Norfolk Boreas Offshore Wind Farm Applicant's Comments on Deadline 13 Submissions

Applicant: Norfolk Boreas Limited
Document Reference: ExA.ASR.D14.V1
Deadline 14

Date: August 2020
Revision: Version 1
Author: Royal HaskoningDHV

PROJECT HORNSEA 3 OFF-SHORE WIND FARM	DATE 07.03.19	DRAWING STATUS INFORMATION	
DRAWING TITLE B1145 - CENTRE OF CAWSTON MITIGATION SCHEME HGV - HGV PASSING POINTS	SCALE(S) AS	DESIGNED AF	
CLIENT ORSTED	SHOWN AS	CHECKED PZ	
	JOB No 1554	APPROVED PZ	
	DRAWING No 03/332	REVISION B

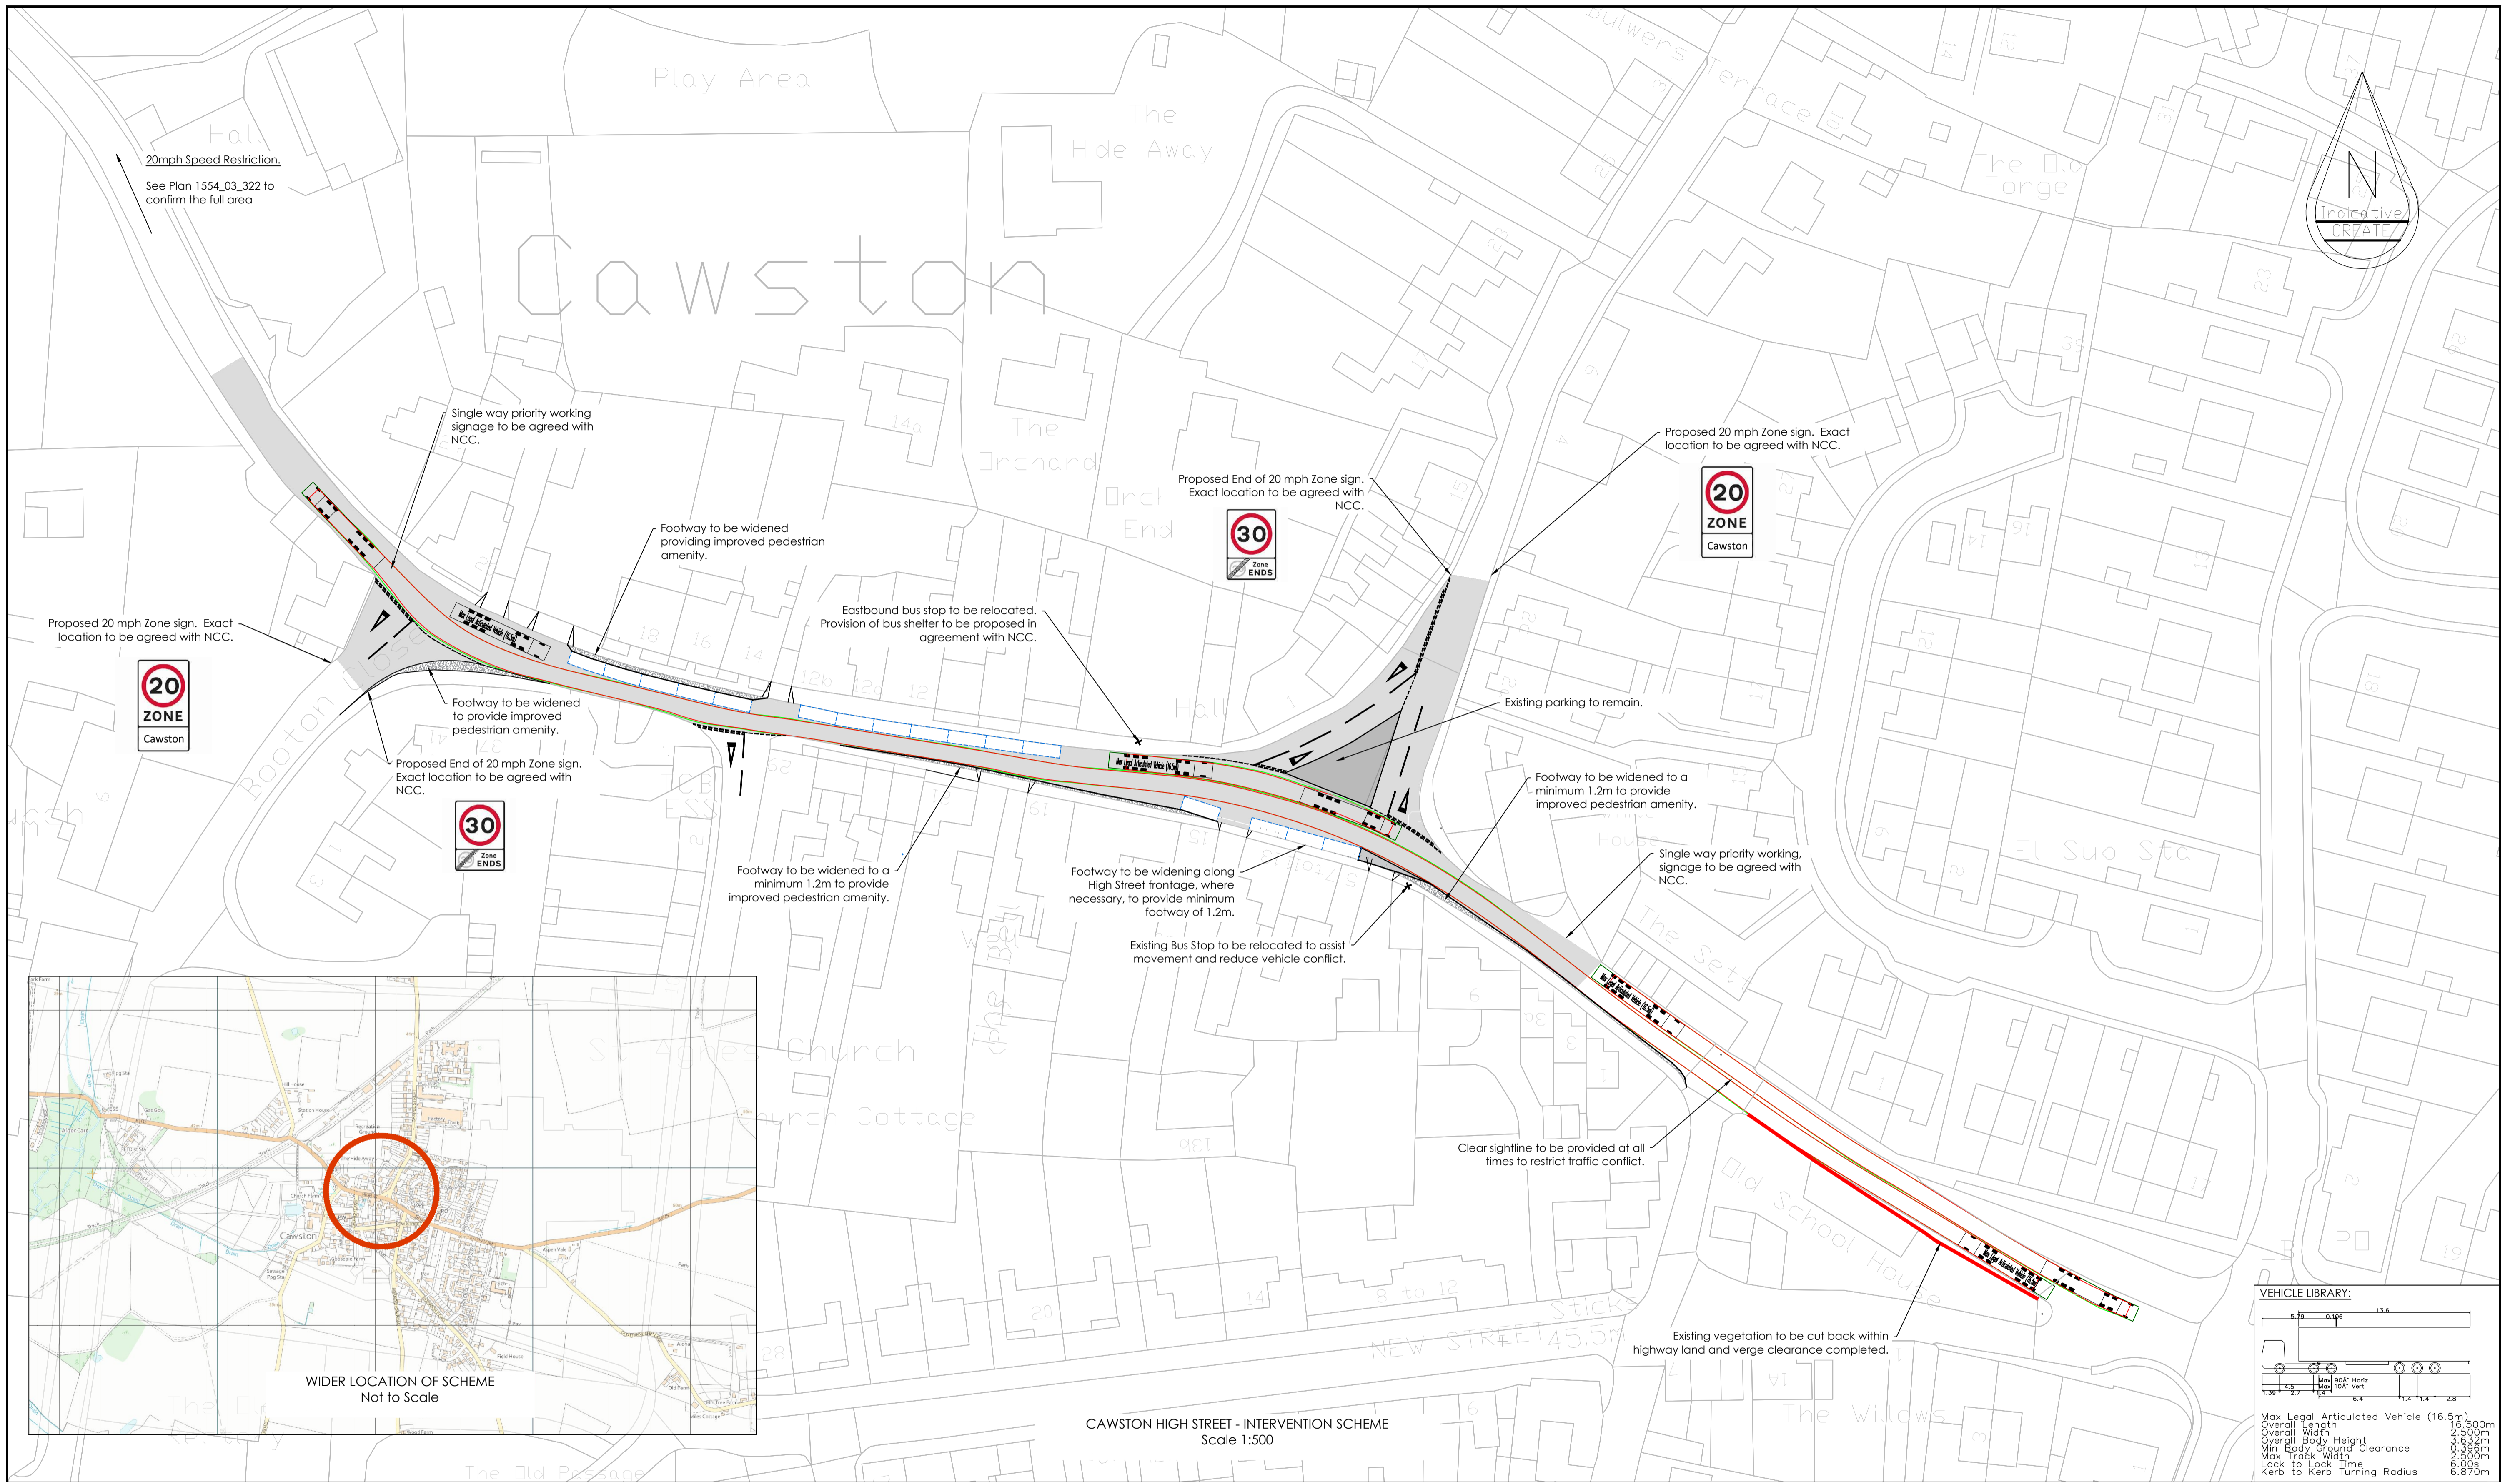
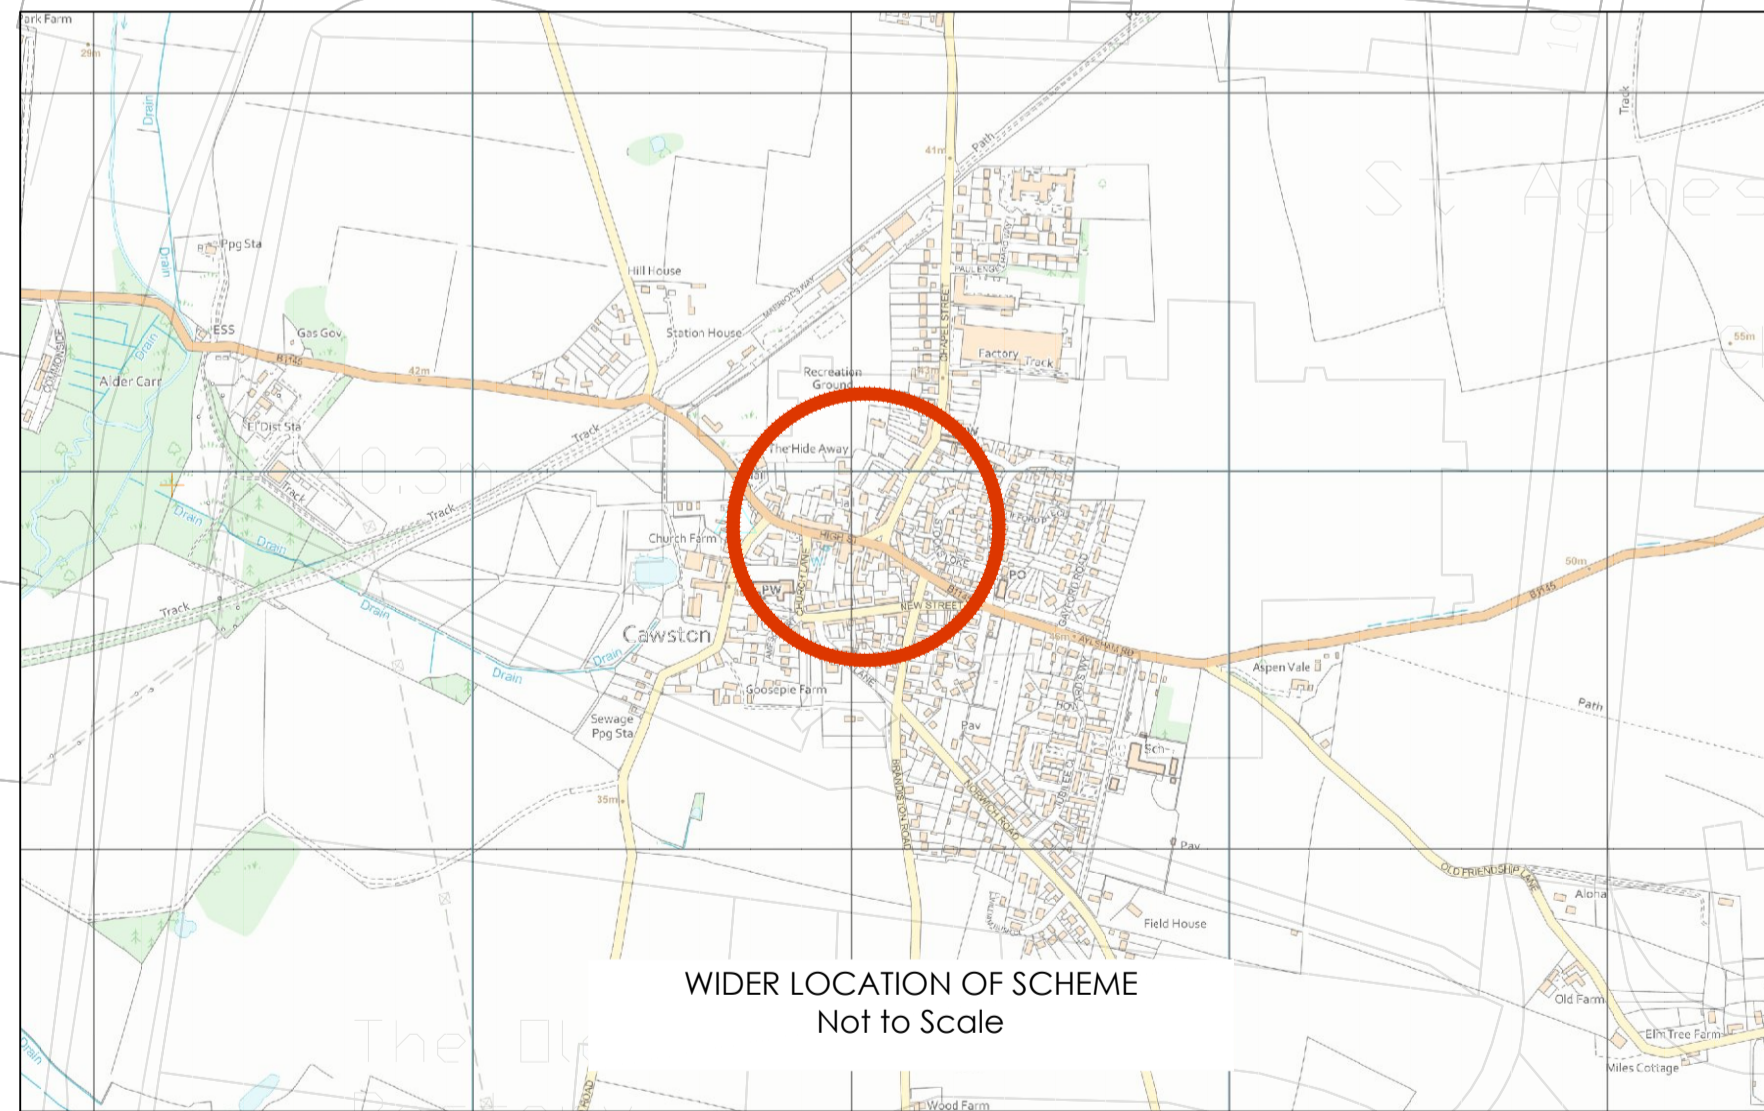
<p>HGV Conflicts</p> <p>CPC suggest that the HIS fails to consider non-windfarm related traffic and provides an example of circumstances in which the HIS will not work with reference to Booton Lane junction.</p>	<p>The HIS design has been informed by validated background traffic surveys, the published Hornsea Project Three traffic demand and the Norfolk Boreas traffic forecasts. The basis of design is for managed Norfolk Boreas arrival rates and randomised arrival rates for other background traffic. The design contains sufficient tolerance to accommodate daily traffic fluctuations and is robust in this respect.</p> <p>The 'blocking back' concern at Booton Lane was recognised by the Applicant early in the HIS development and the eastbound B1145 approach to Booton Lane was modified from the original HP3 design, to accommodate additional HGV queuing and thus build more resilience to potential blocking back events. The Deadline 4 Technical Note 'Revised Cawston HIS' [REP4-016] details the re-configuration of the parking in the High St informed by CPC's kerbside capacity parking surveys, allowing the removal of two parking bays in the vicinity and thus creating the space for additional queuing capacity.</p> <p>Drawing TP-PB5640-DR018 in Appendix 6 OTMP Version 5 [REP10-019] details three tipper HGVs positioned in the waiting area adjacent to Booton Lane. This is illustrative</p>

Summary of Submission	Applicant's Comments
	<p>only for the purpose of showing HGV waiting capacity and worst case swept paths, it is not intended as a depiction of forecast HGV arrival rates. The 50m forward visibility referred to by CPC is the total clear visibility not the required safe visibility. A 26.7m HGV stopping distance can be derived from UK design standards including driver reaction time. It provides a robust proxy for the minimum driver distance to judge the road ahead and manoeuvre accordingly. For the scenario CPC refer to this would afford adequate time for a driver to judge the end of a queue and come to a stop at a place that will not obstruct approaching traffic.</p> <p>All UK standards are based on dry weather conditions. The Highway Code supplements these standards by directing drivers to slow down in inclement weather conditions.</p> <p>Further assurance against the occurrence of blocking back is set out in the OTMP [REP10-016], which makes a commitment to driver information packs which identify safe pull-over areas for HGV drivers to let slow moving platoons pass.</p> <p>NCC have agreed to the principle of developing these areas just outside the Cawston Village extents ensuring that appropriate width/length and forward visibility is provided. NCC have further agreed the principle that these areas would be developed pre-commencement when the HGV fleet composition would be refined and secured via a Section 278 Agreement and included in the final Traffic Management Plan.</p> <p>A review of the network indicates there are potential sites on the eastbound and westbound approaches to the HIS on the outskirts of Cawston with an approximate minute journey time to the High Street. This short journey time limits the chance of a further platoon building up as the HGV continues on its journey following a pull-over manoeuvre.</p> <p>The Applicant therefore reaffirms the ES traffic and transport cumulative impact assessment [APP-237] conclusion that the HIS mitigates the potential for significant driver delay through Cawston.</p>
